CITY OF ALBUQUERQUE

**Re: BJ's Restaurant and Brewhouse Grading and Drainage Plan
Colleen Rezac Engineer's Stamp with No Date (B14D004E)**

Based upon the information provided in your submittal received June 25, 2014, the above referenced plan is approved for Site Plan for Building Permit action by the DRB.

GRADING LEGEND

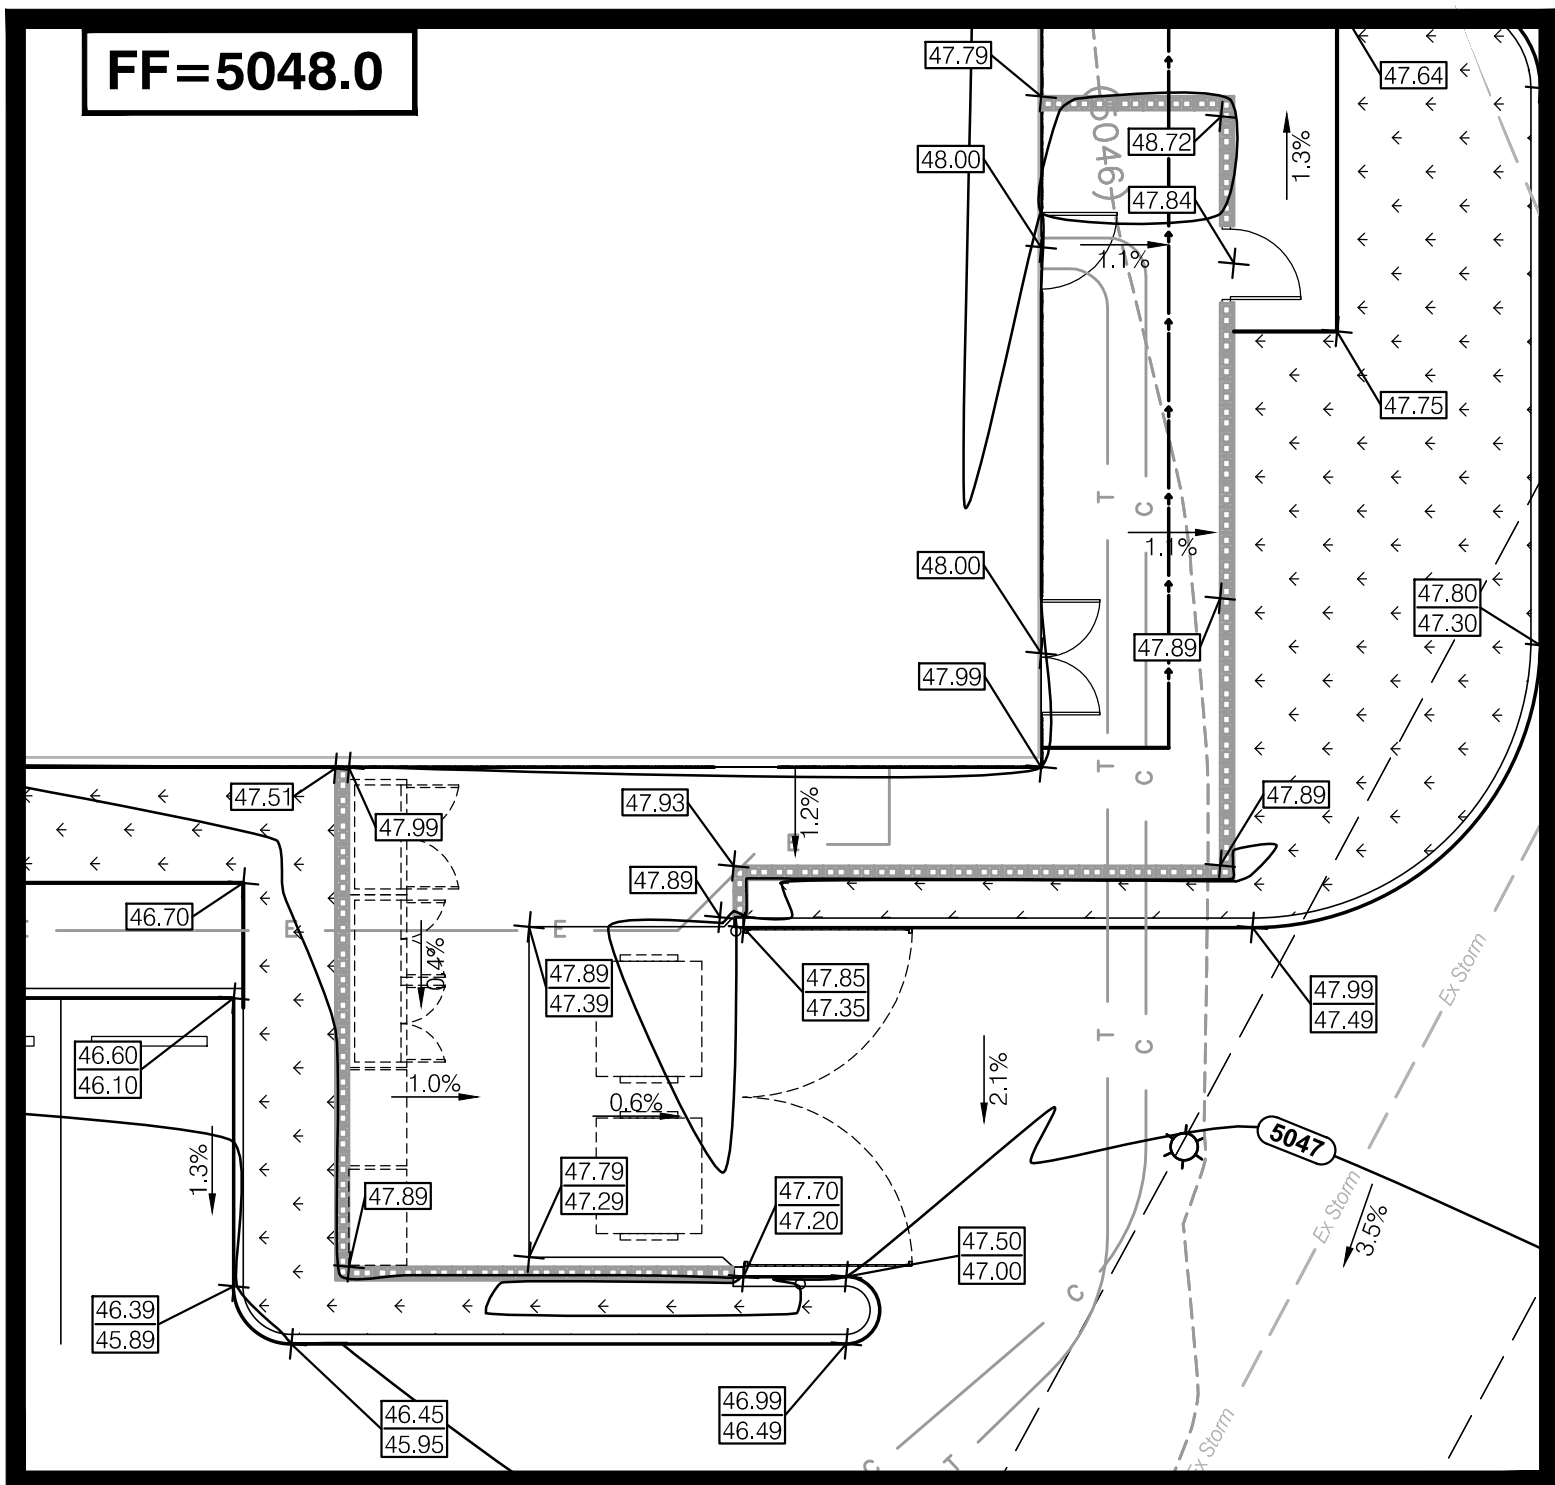
1. Schedule Note C states the storm pipe is 12 inch, but Schedule Note 4 calls out a 4 inch invert. Revise Note 4. Provide a call out for Schedule Note 8 and size of pipe. Call out a transition for connecting HDPE to concrete pipe.

4. No bio-swale detail is provided as has been called out. Provide the detail.
5. Include openings in all the islands for drainage to enter.
6. Plan note 2 calls for utilities to be relocated to the proposed grade. Be specific about which utilities and how they will be handled.
